STATE OF NORTH CAROLINA
DEPARTMENT OF TRANSPORTATION

Addendum No. 1

RE: Contract # C204056

I-40 From MP-32.95 (McDowell County Line) To MP-119.13 (Catawba County Line)

TYPICAL SECTION NO.1 MILLING

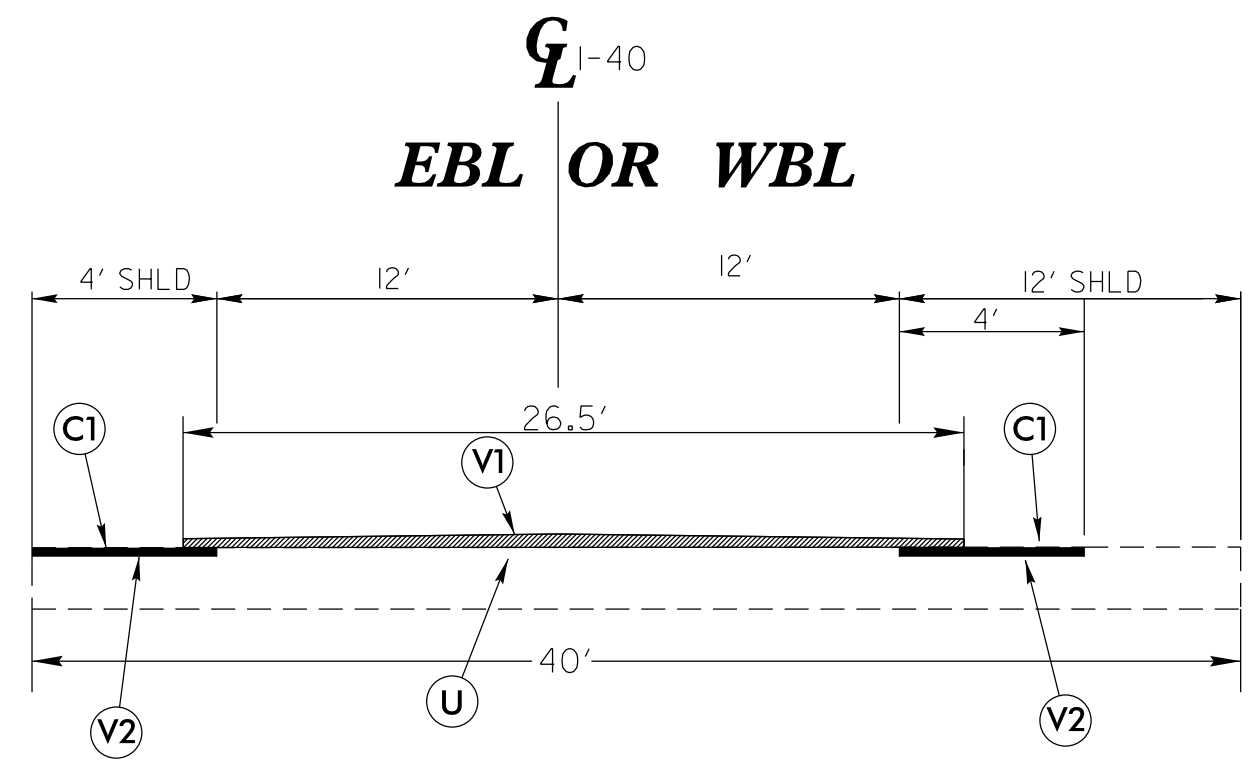
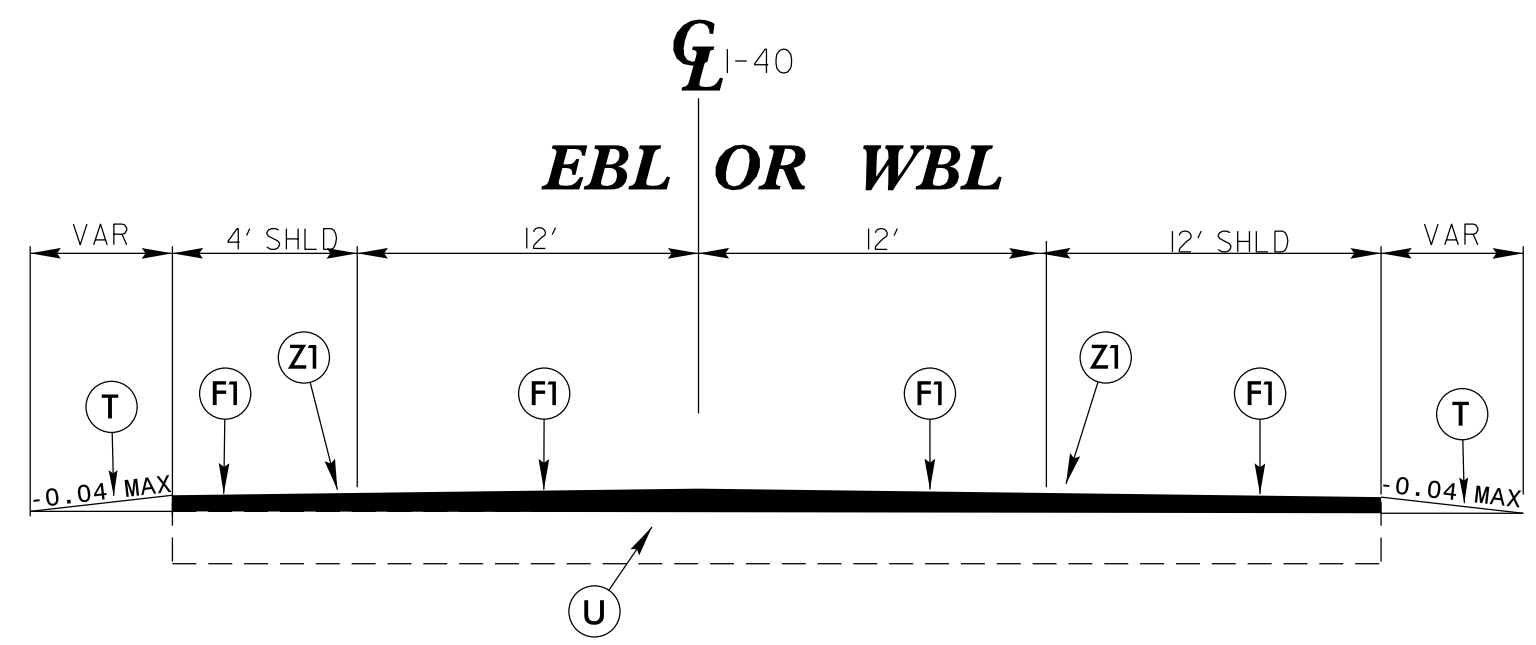
Sheet No.	Revisions
5 thru 11	Revised the "Pavement Schedule" to clarify the difference between milling and fine milling
16	Revised the "Summary of Quantities" to reflect the below mentioned pay item quantity change
